## Building

## Energy

6 TYP WALL CLEARANCES @ GRADE  
1 1/2\"/>

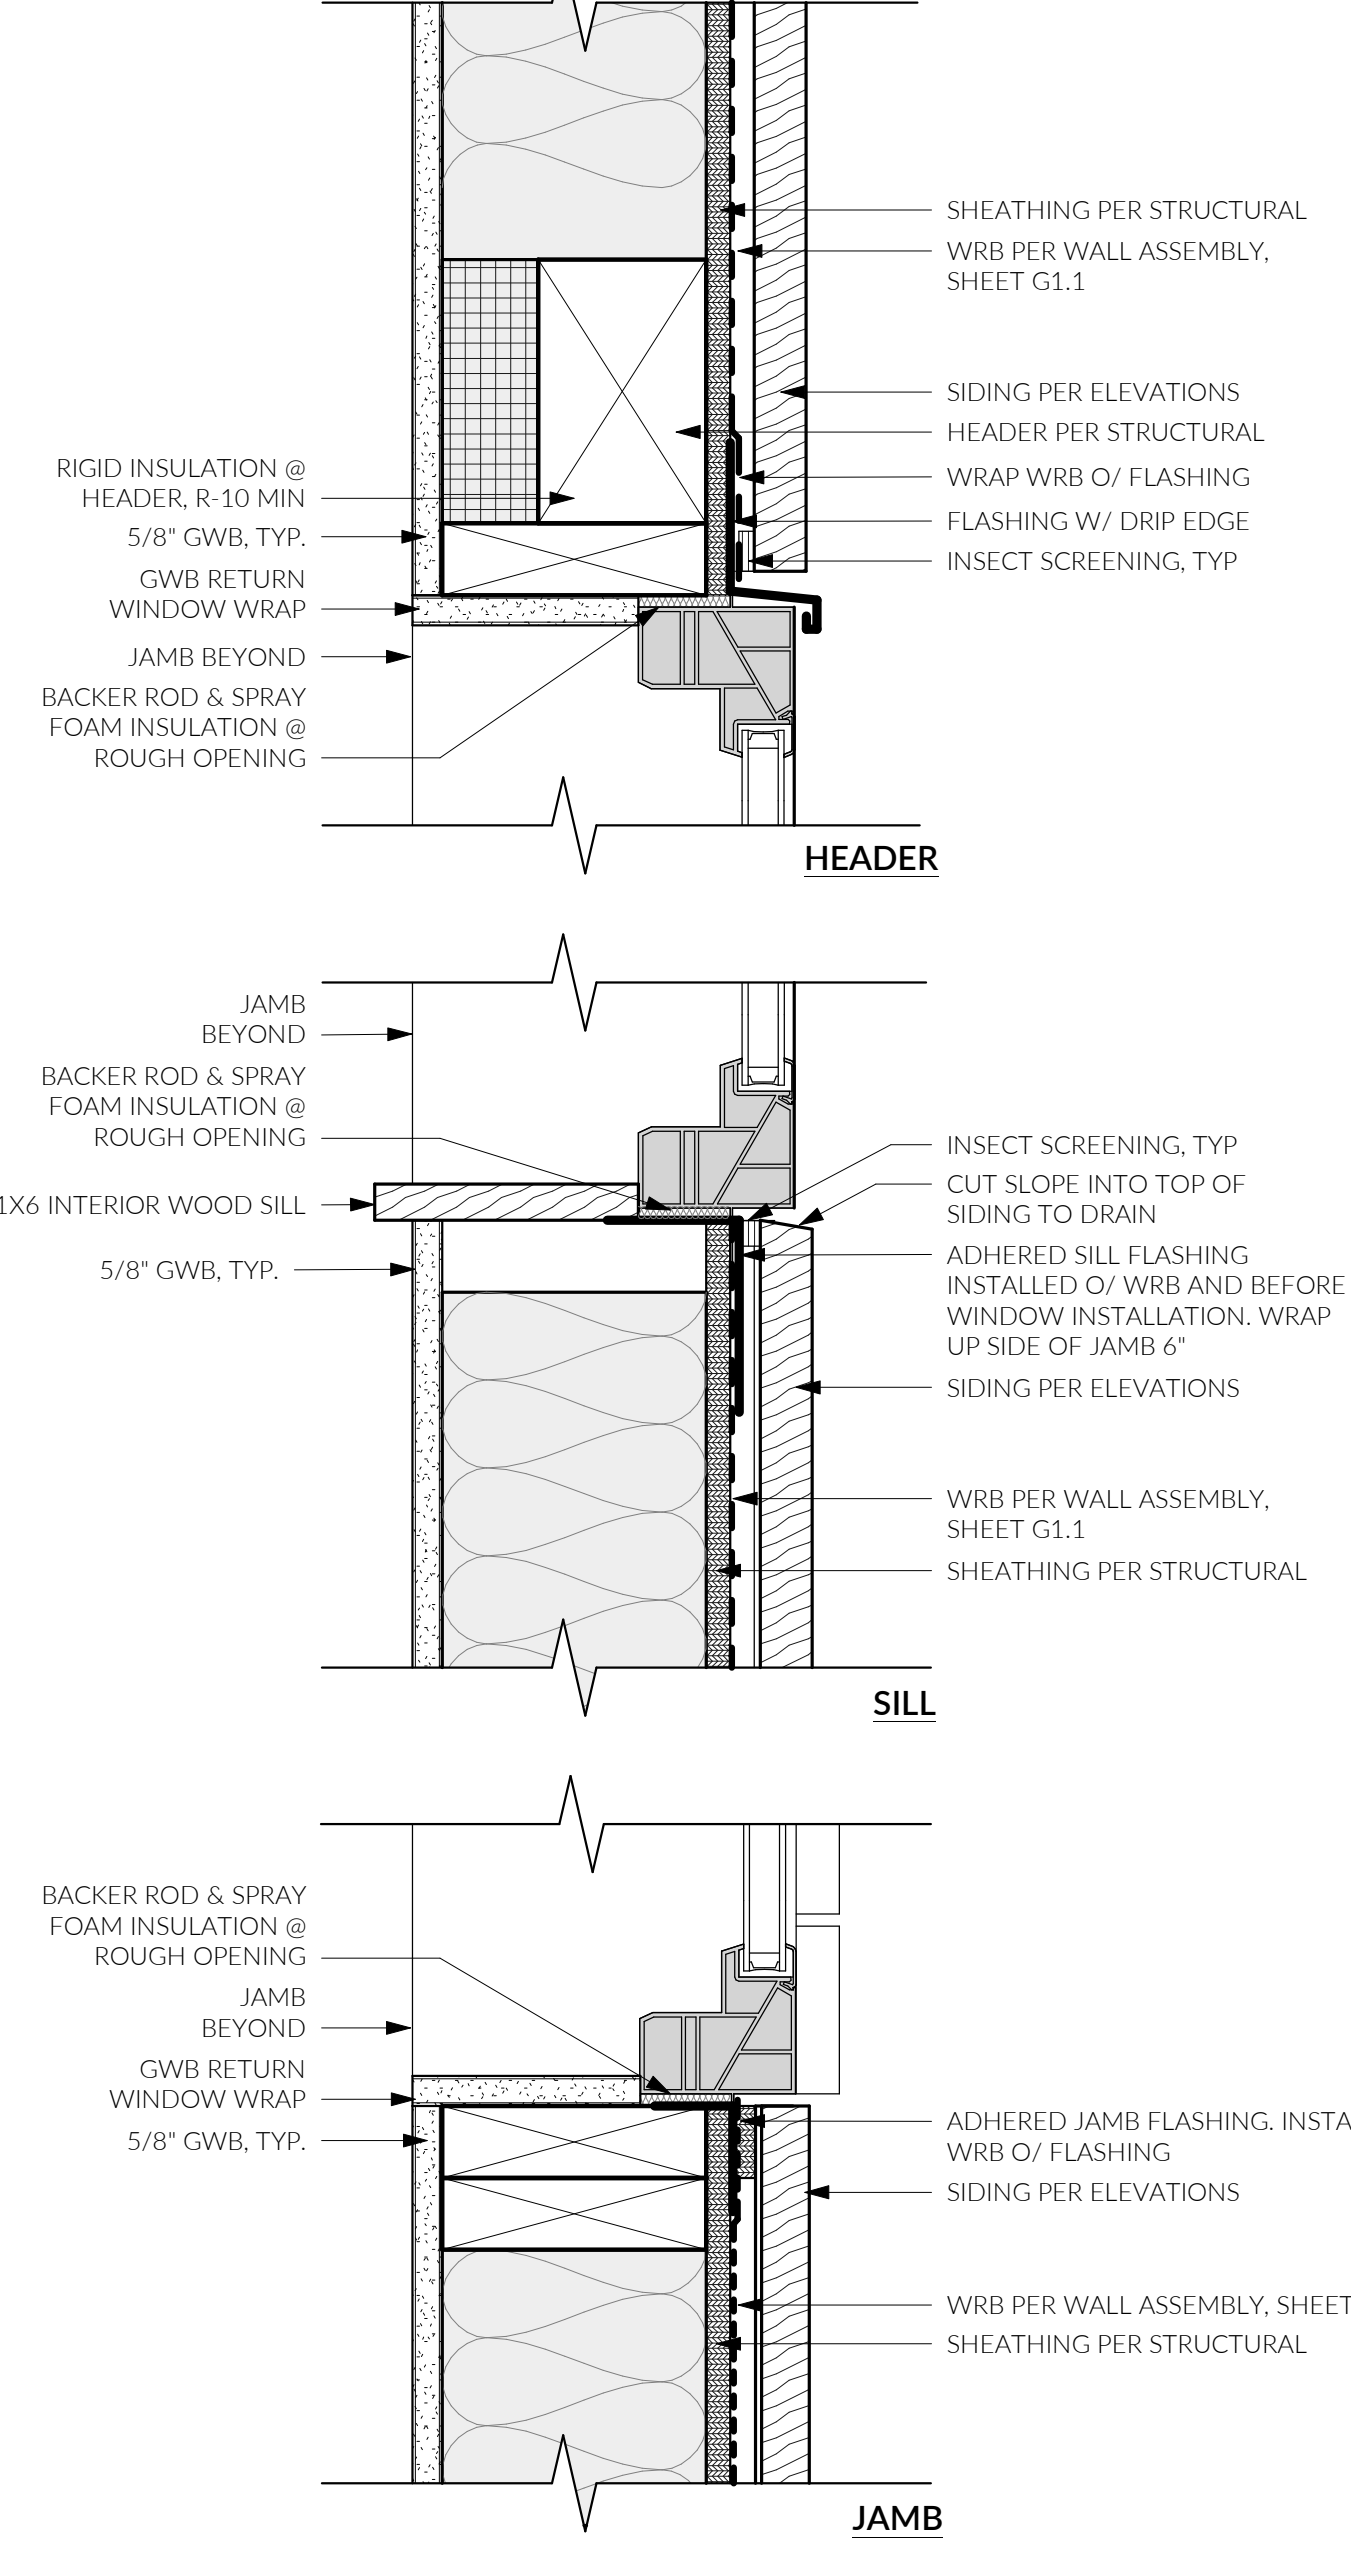
- a. *Heat detector added to floor plan. Please see sheet A2.0.*
- 6.) IRC R317.1 requires wood framing members that rest on concrete to be not less than 8" from exposed ground unless they are pressure treated and wood siding, sheathing, and wall framing...

- a. *Detail added to sheet A5.0 showing relevant dimensions/requirements.*
- 7.) The crawl space ventilation calculations on Sheet A1.2 use a reduced ventilation area of 1:1,500. When applying the exception to IRC R408.2, you are required to incorporate a radon vent system into your design...

9 HANDRAIL PROFILE  
6" = 1'-0"

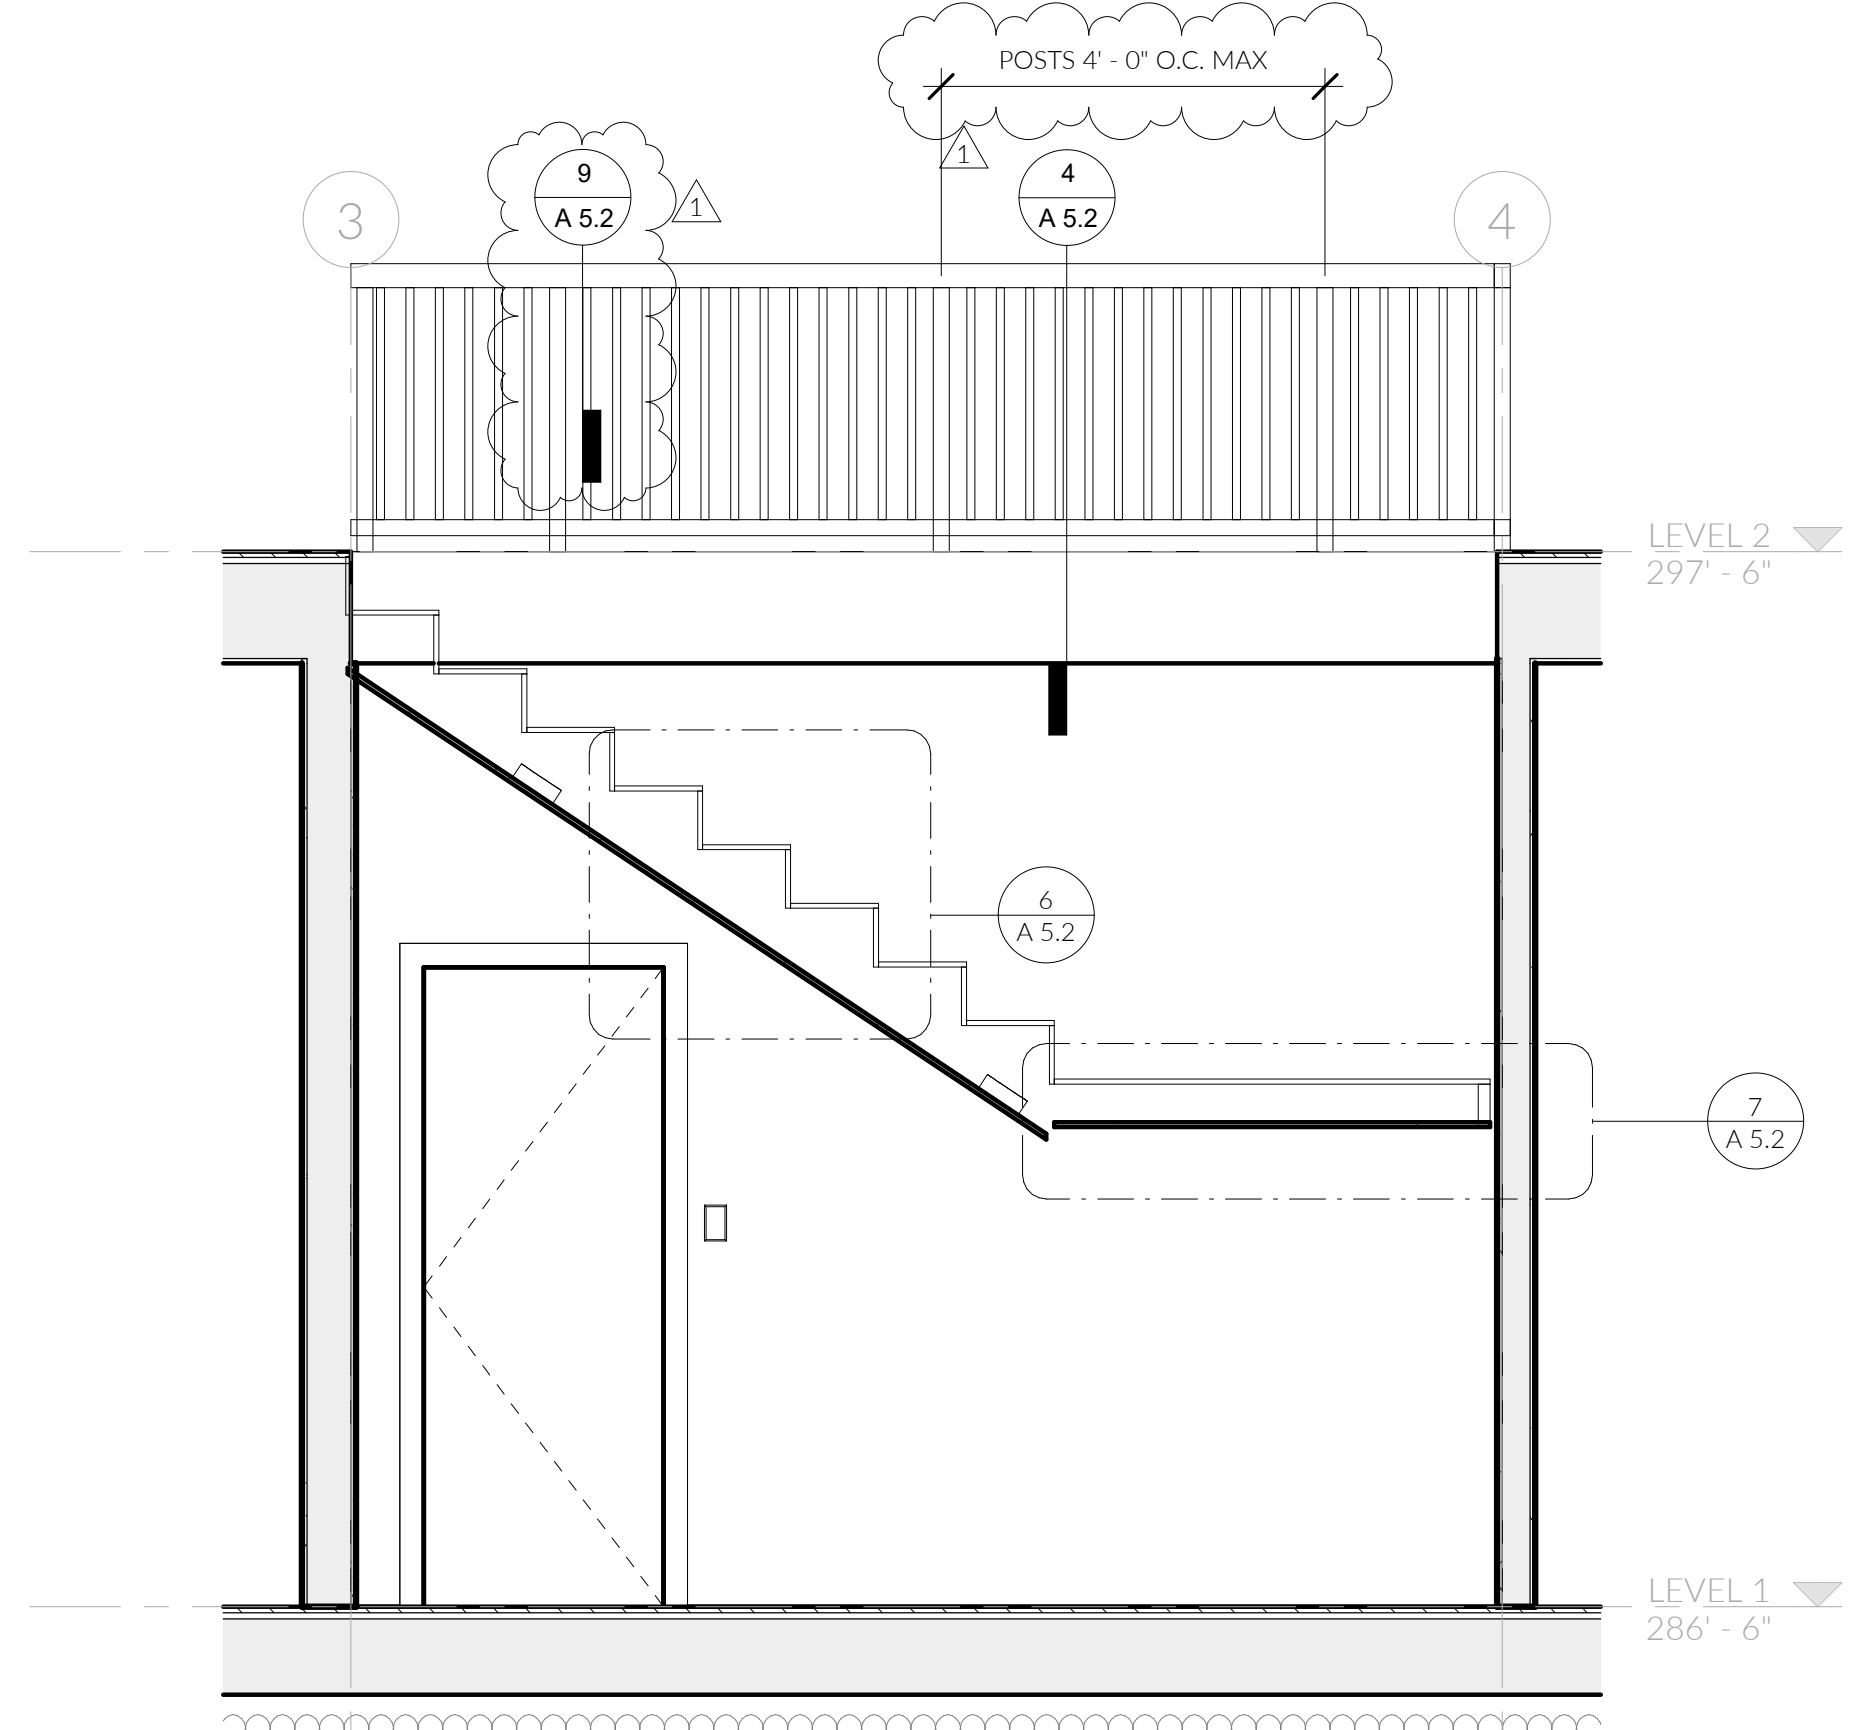
- a. *Note calling out fire sprinkler requirement/type added to sheet G1.0.*
- 3.) Please clearly show the location of the code-required handrail at the stairs in plan. Where the handrail is located at the top of a guard, the configuration must meet the requirements of IRC R311.7.8.5...

- a. *Handrail details updated. Please see sheet A5.2.*
- 4.) We do not find any notes on the drawings addressing the interconnection of smoke alarms and carbon monoxide alarms as required in IRC R314.4 and R315.5. Provide notes on the drawings addressing the interconnectivity requirement.
